WEST SUSSEX COUNTY COUNCIL CONSULTATION

TO:	Arun District Council FAO: Simon Davis
FROM:	Highways, WSCC
DATE:	20 th December 2018
LOCATION:	84, Flansham Lane, Bognor Regis, PO22 6AH
SUBJECT:	FP/269/18/DOC Approval of details reserved by condition imposed under ref FP/180/17/PL relating to Condition Nos 6, 7, 8 and 12.
RECOMMENDATION:	☒ Advice ☐ Objection ☐ Modification ☐ No Objection ☐ More Information ☐ Refusal
S106 CONTRIBUTION TOTAL:	£N/A

DRAWING
**PROPOSED
LANDSCAPE PLAN**

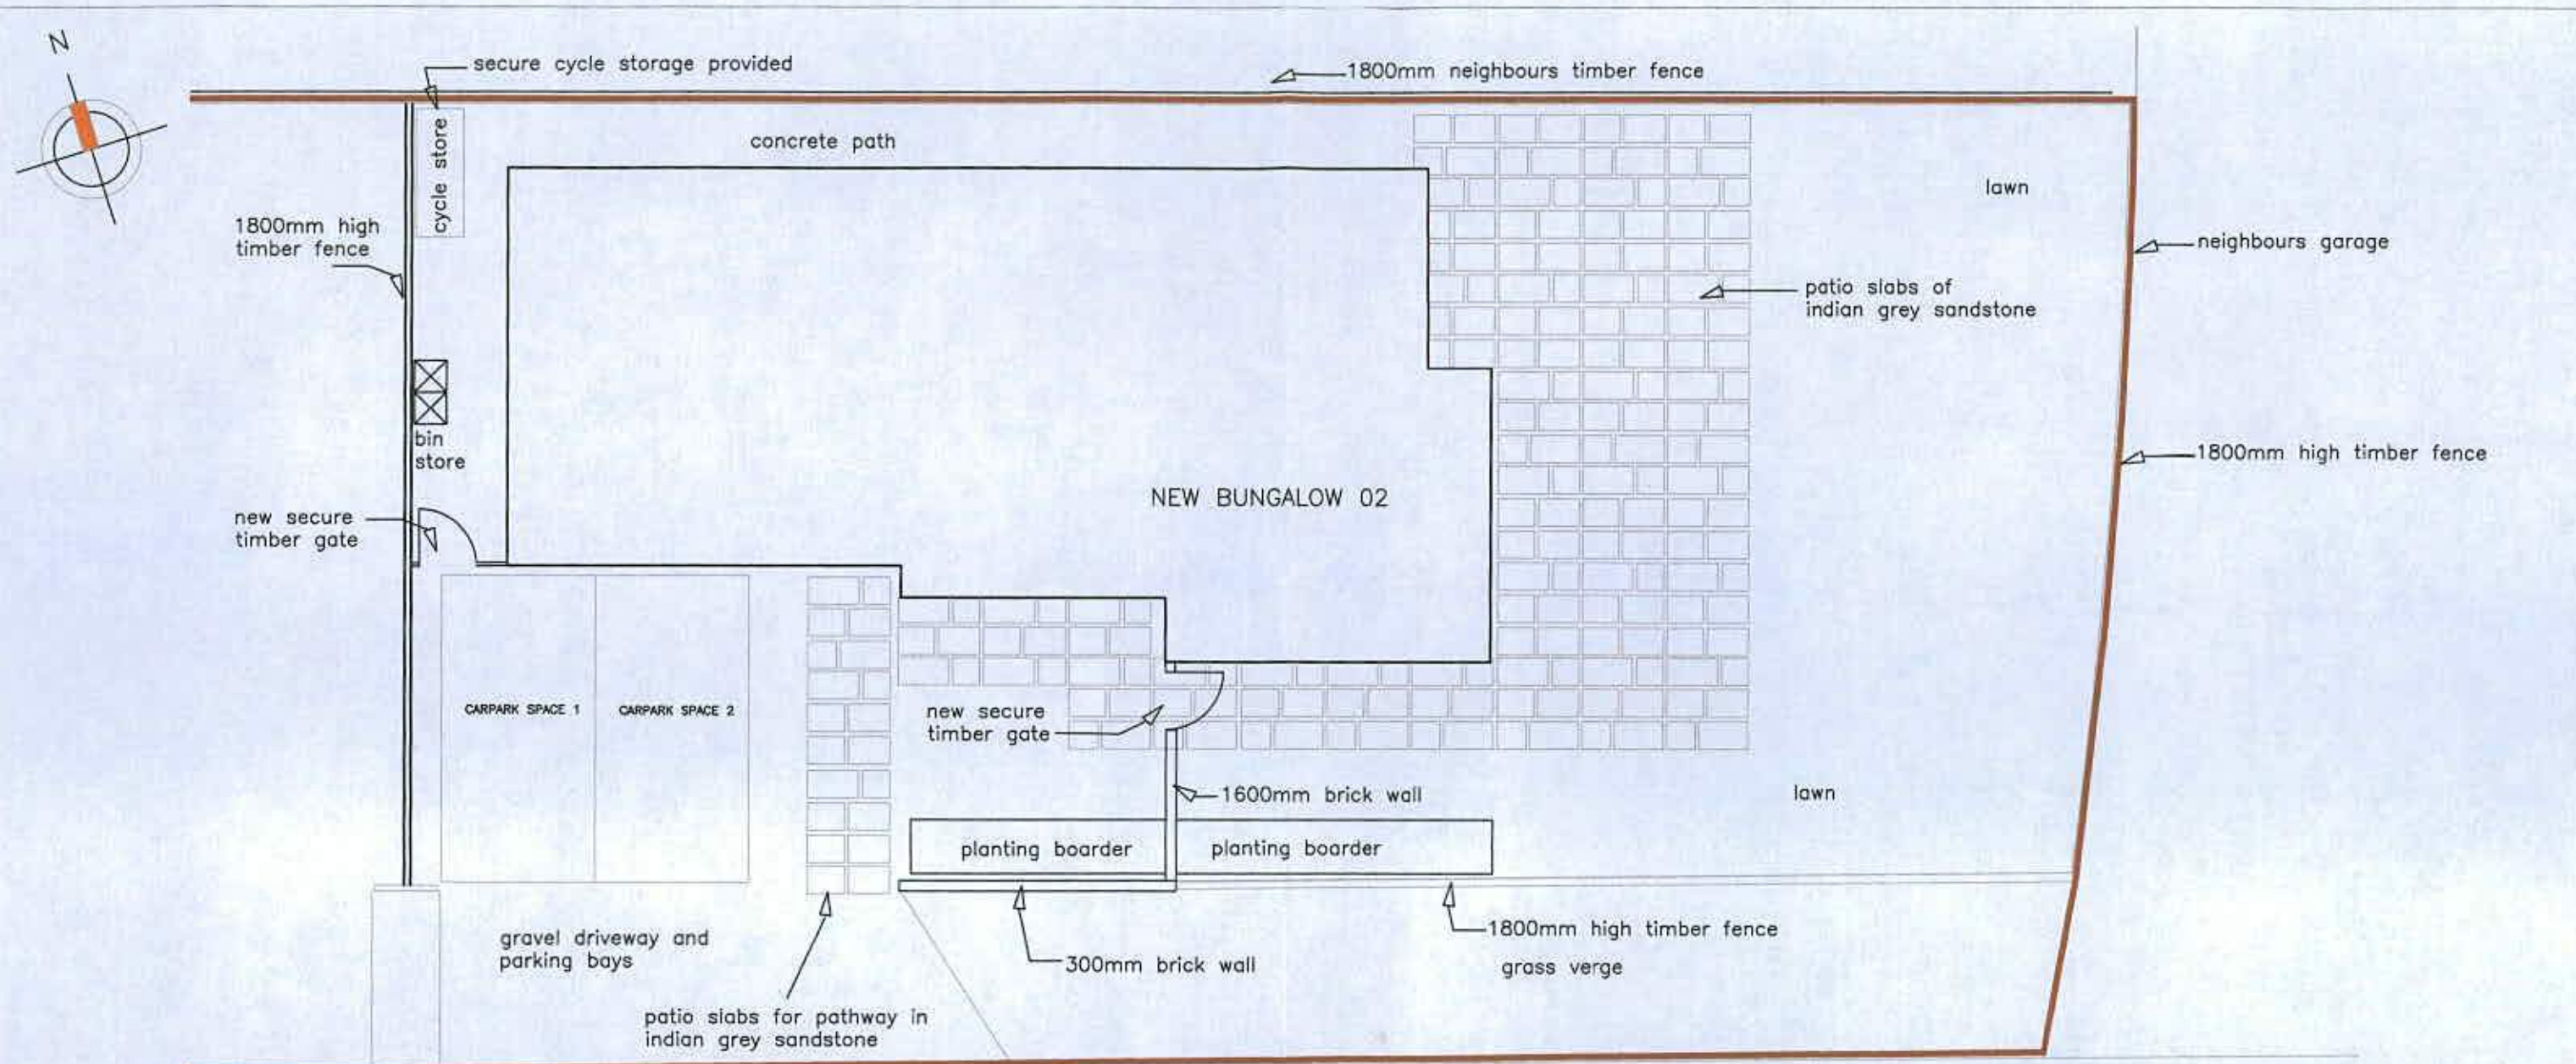
Only one of the proposed dwellings has been built and the plans indicate the location of a secure bicycle store to the west of the dwelling. The plans and details pertaining to the condition are acceptable.
